Ribble Valley Borough Council
Housing & Development Control

Your ref: 3/2023/0384
Our ref: D3.2023.0384
Date: 10th August 2023

Application no: **3/2023/0384**

Proposal: **Proposed new 4 bedroom dwelling and creation of new access on land to the side of 3 Grindleton View.**

Date: 09/05/2023	Drawn by: JHolden
Scale: 1:100 @ A1	Ref: 003
Client: Mr & Mrs Bradley	Revision: B

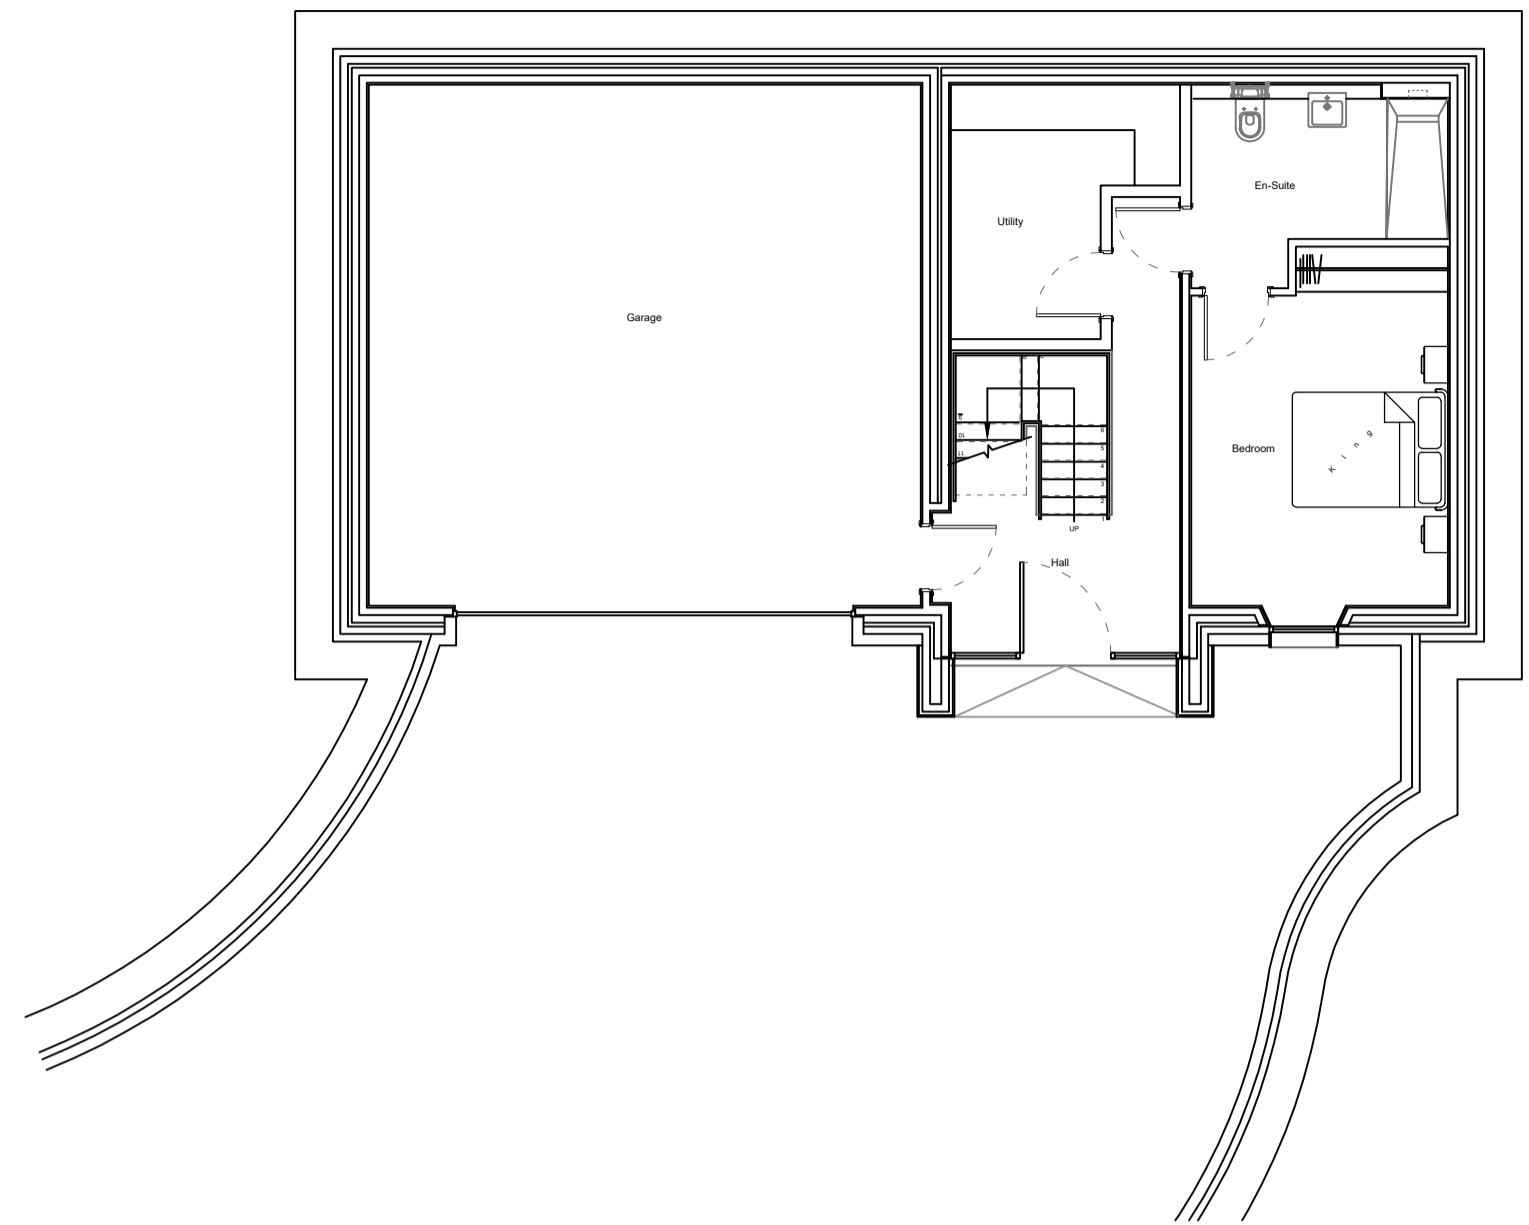
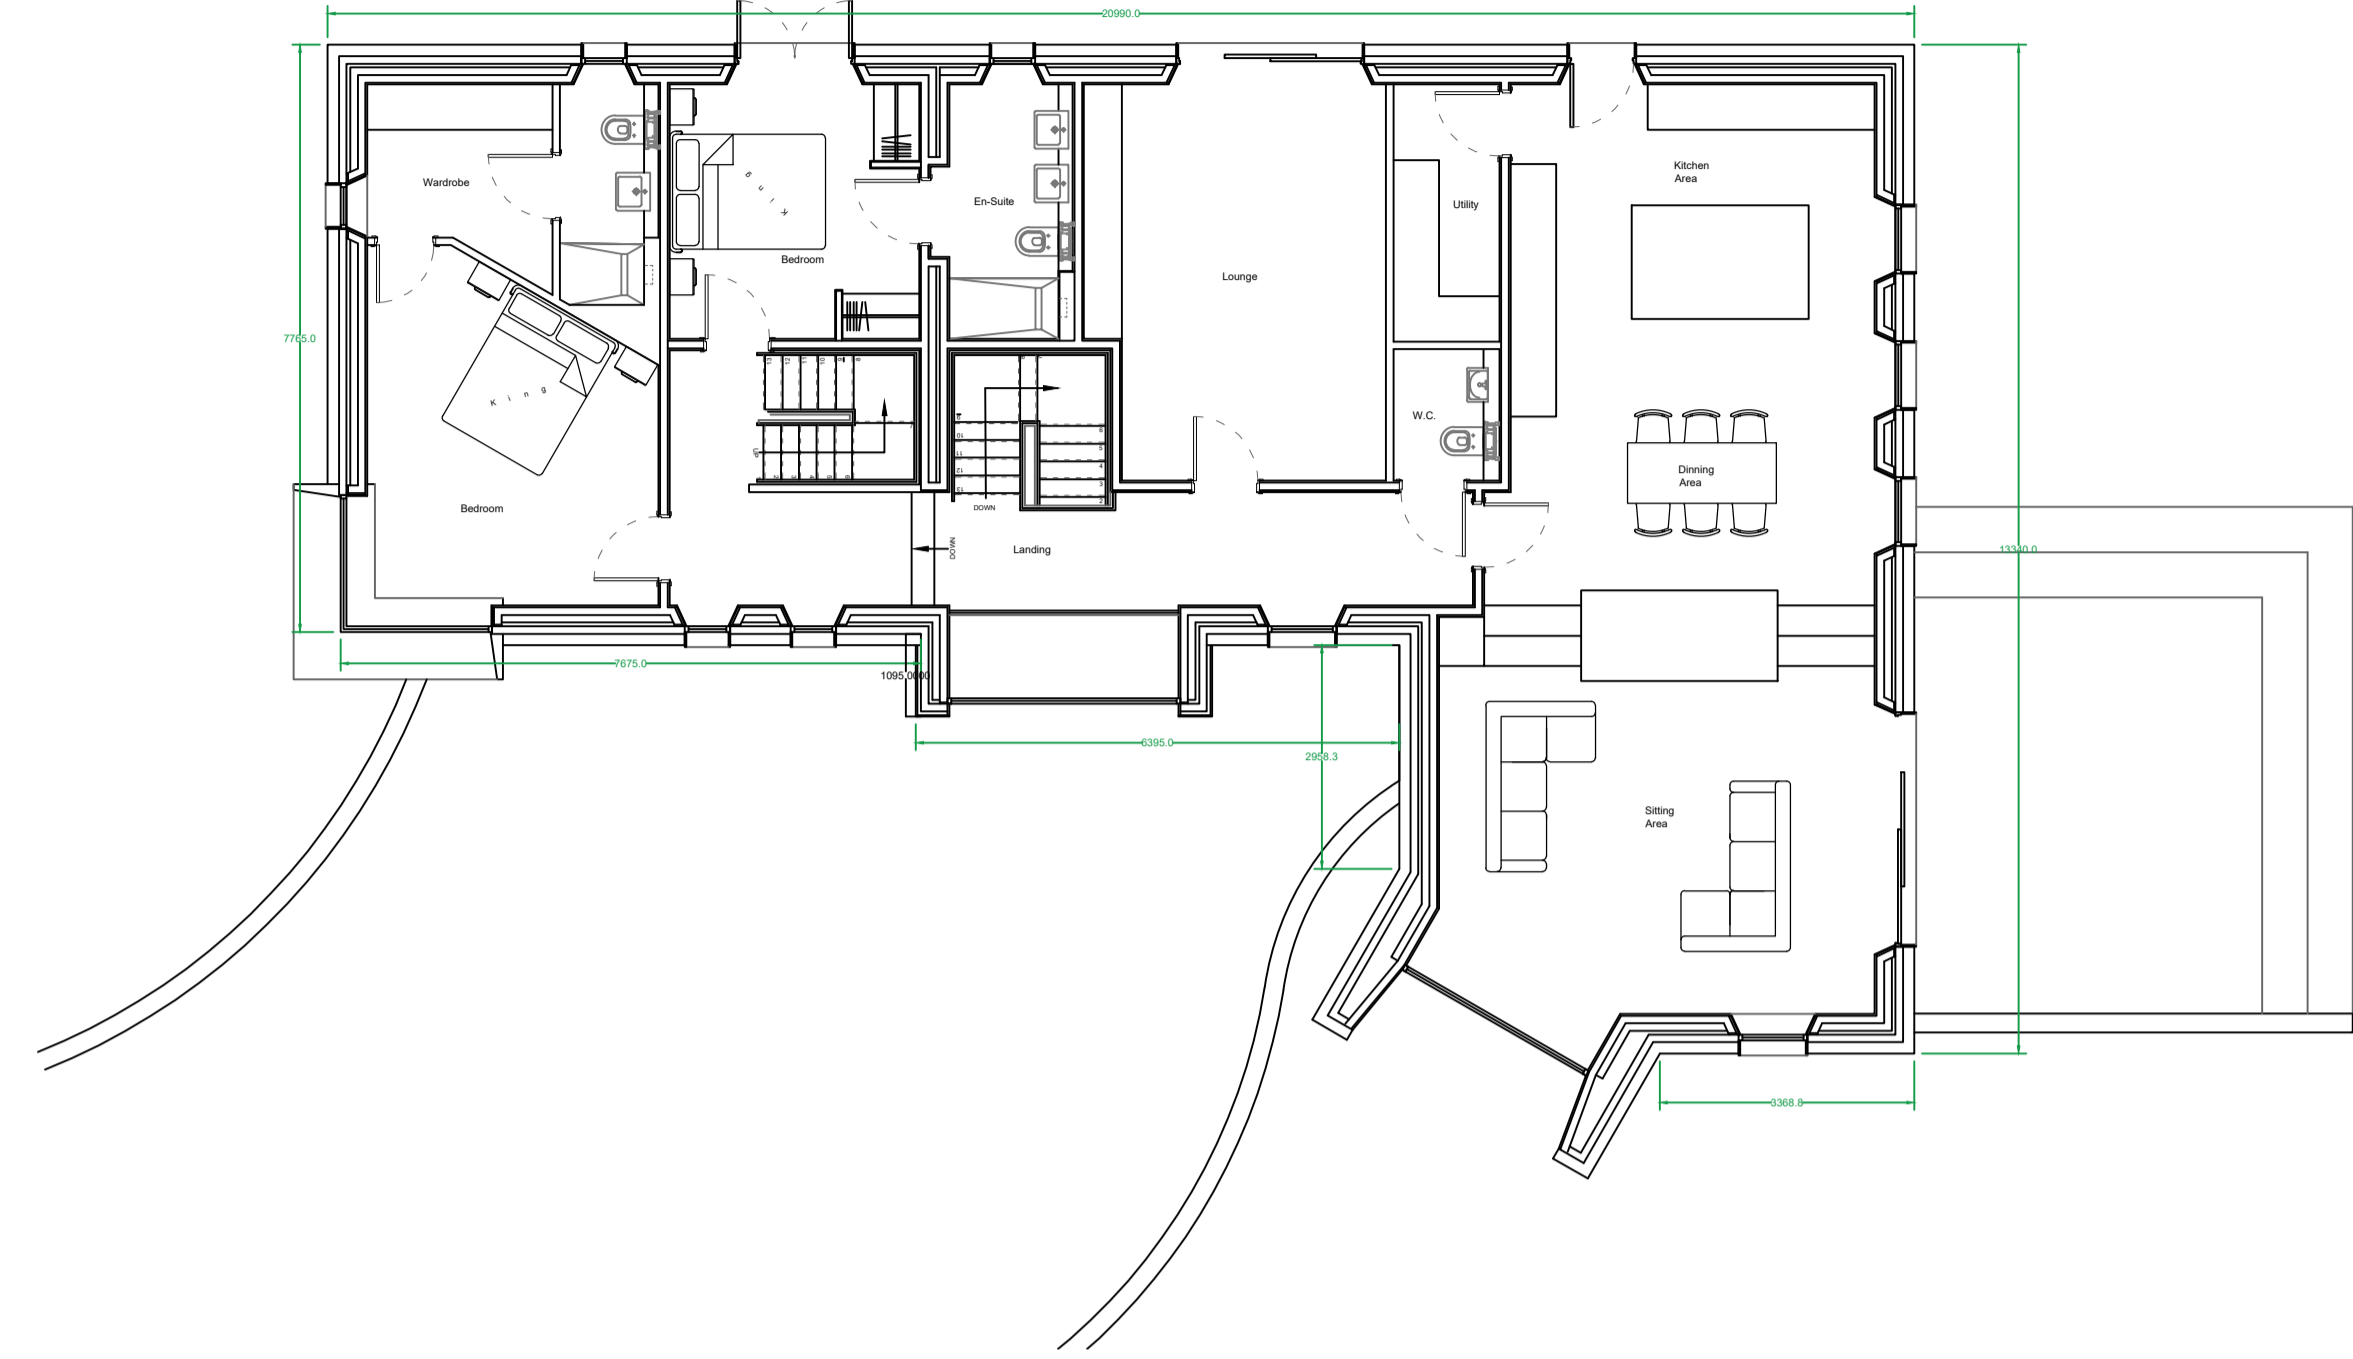
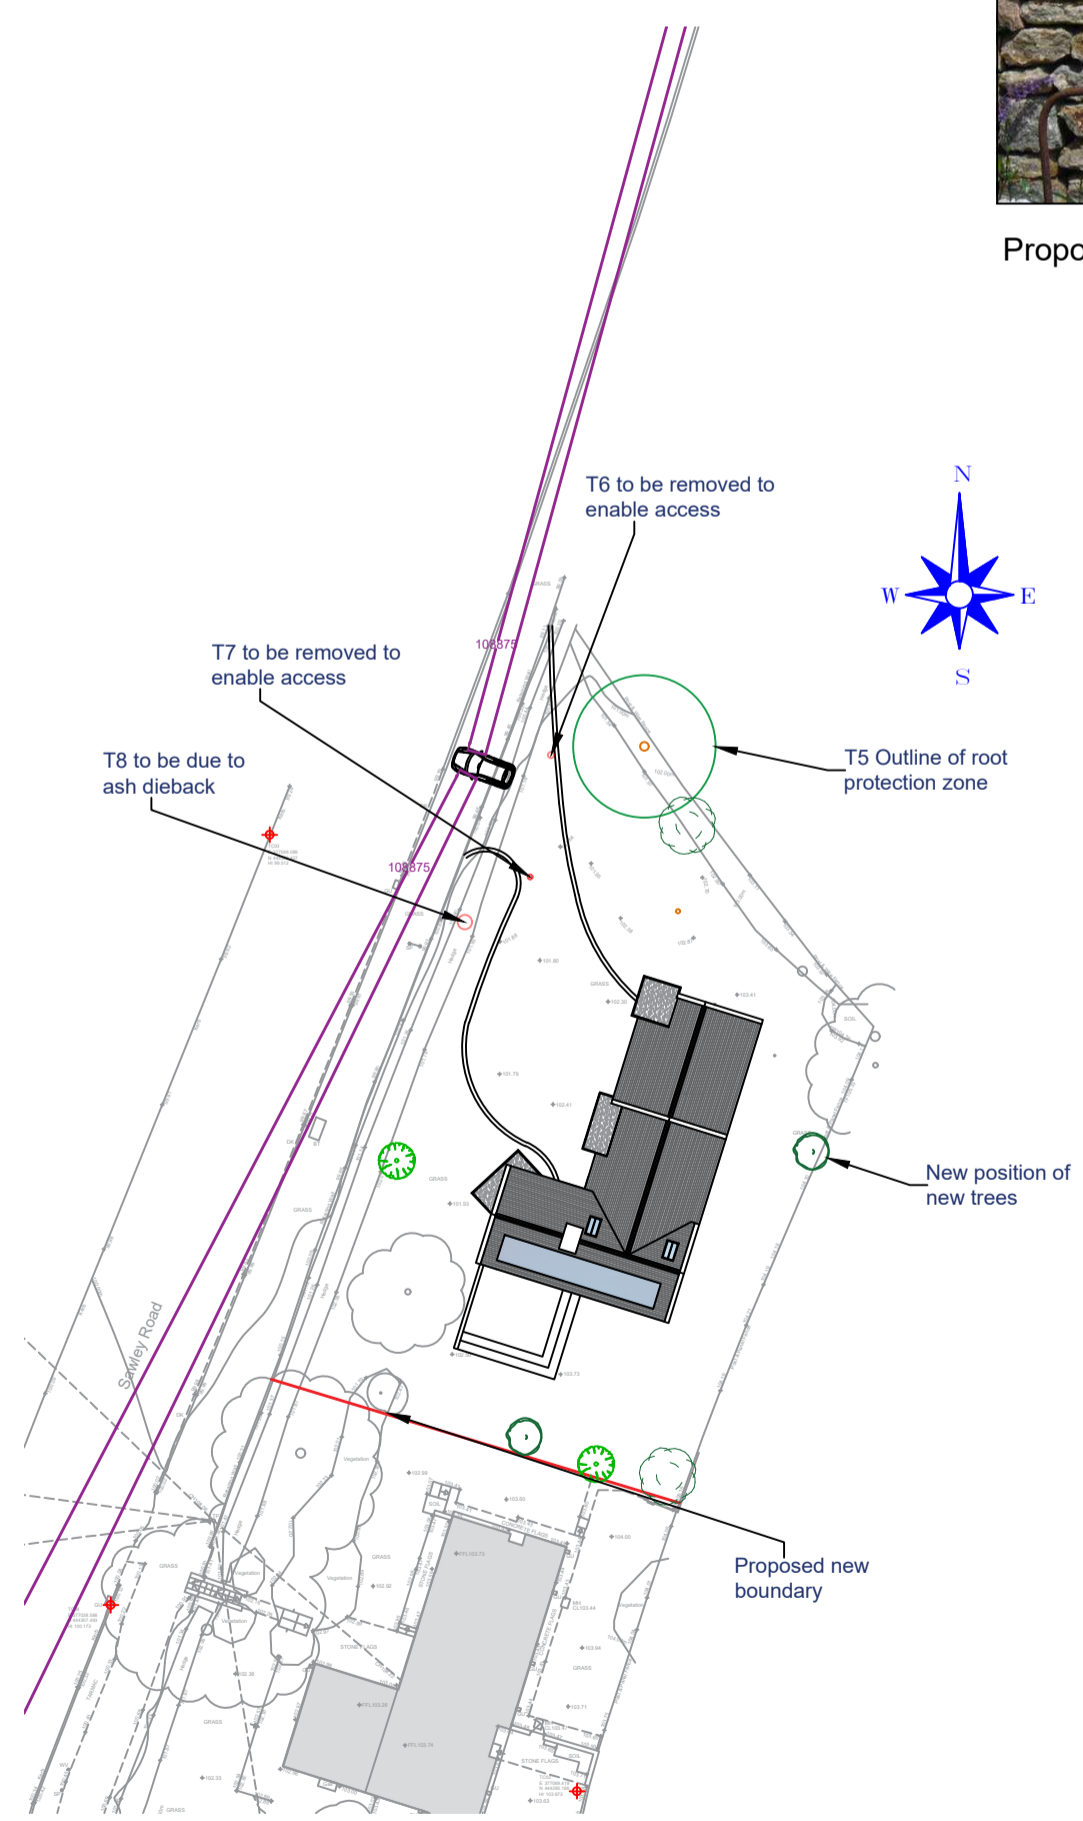
The LHA have reviewed Holden drawing number 003 Rev B titled "Proposed Plan" and have no comments to make regarding the access width, with it complying with the LHAs guidance when serving a single dwelling.

The LHA would advise that the access should be located within the 30mph speed limit in any case. To ensure this occurs, the speed limit signs should be plotted on any amended plan. Should the access conflict with the speed limit signs and the road markings, the Applicant will be liable to the relocation of these signs and road markings.

The LHA also require on an amended plan, a footway to be provided to the west of the site access connecting to an existing footway which provides access to the closest bus stop and provides a segregated pedestrian facility to Chatburn village centre, where local amenities are found. The LHA will request that the footway starts internally at the site access and uses the grass verge which fronts Sawley Road. The footway should be a minimum of 2m wide and provide an uncontrolled pedestrian crossing via dropped kerbs and tactile paving to the existing footway on the other side of the carriageway. This will provide a connection to the other bus stop which is located opposite the site.

To create the proposed site access, a part of the retaining wall located at the back of the highway verge will need to be demolished as part of any access works. Currently, the LHA are reviewing whether the retaining wall belongs to Lancashire County Council or whether it belongs to a third party.

The LHA are also concerned regarding the gradient at the site. The LHA require site section drawings of the access with the site being extremely steep. The LHA remind the Agent that the LHA require the gradient to be no steeper than 1 in 10 and the gradient should be relatively flat across the highway verge. Therefore, the LHA require construction details as to how this can be achieved with the gradient being close to 1 in 1 in places.

The LHA have reviewed Holden drawing number 003 Rev B titled "Proposed Plan" and are aware that the parking arrangements complies with the LHAs parking guidance as defined in the Joint Lancashire Structure Plan.
